Comments for Planning Application 21/00141/FUL

Application Number: 21/00141/FUL

Address: 14 Pound Field Close Oxford OX3 9NL

Proposal: Erection of two storey side extension to create 1 x 1 bed dwelling house. Provision of car parking, bin and cycle stores and associated landscaping.

GROUND FLOOR/ SITE/ BLOCK PLAN

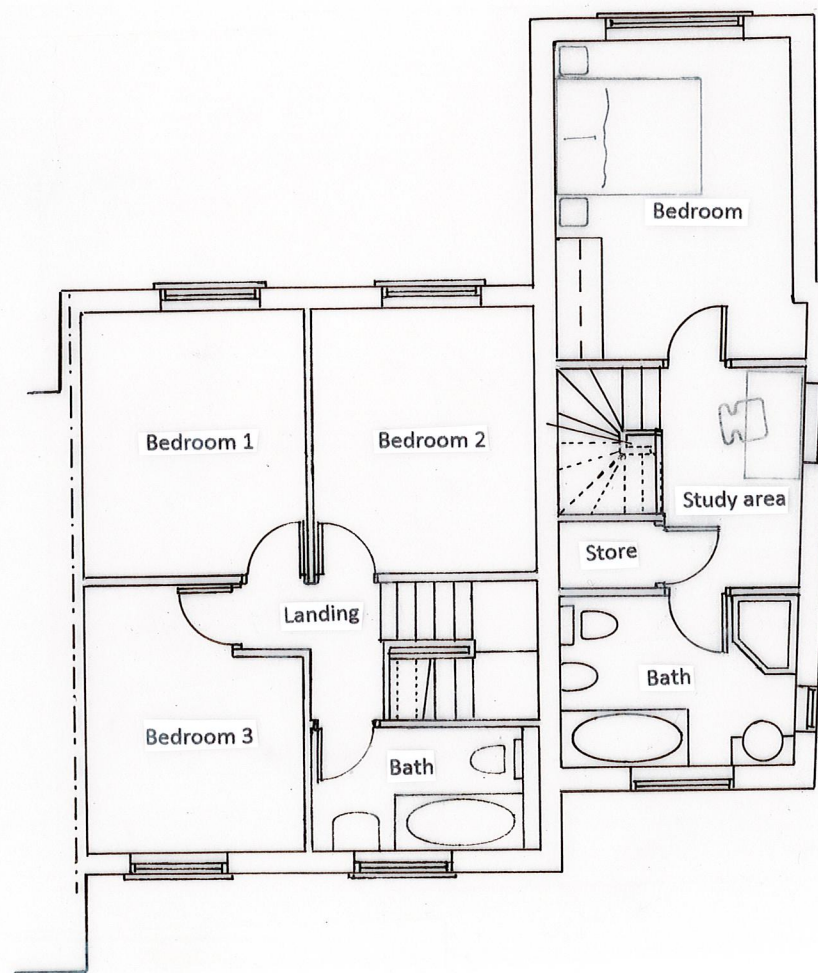
Cycle Parking - The property demonstrates 2 covered and secure cycle parking spaces per flat. This conforms with 2036 local plan policy.

Car Parking - The application provides the maximum level of off-street parking per dwelling, 1 space. The parking layout and parking space dimensions are considered acceptable.
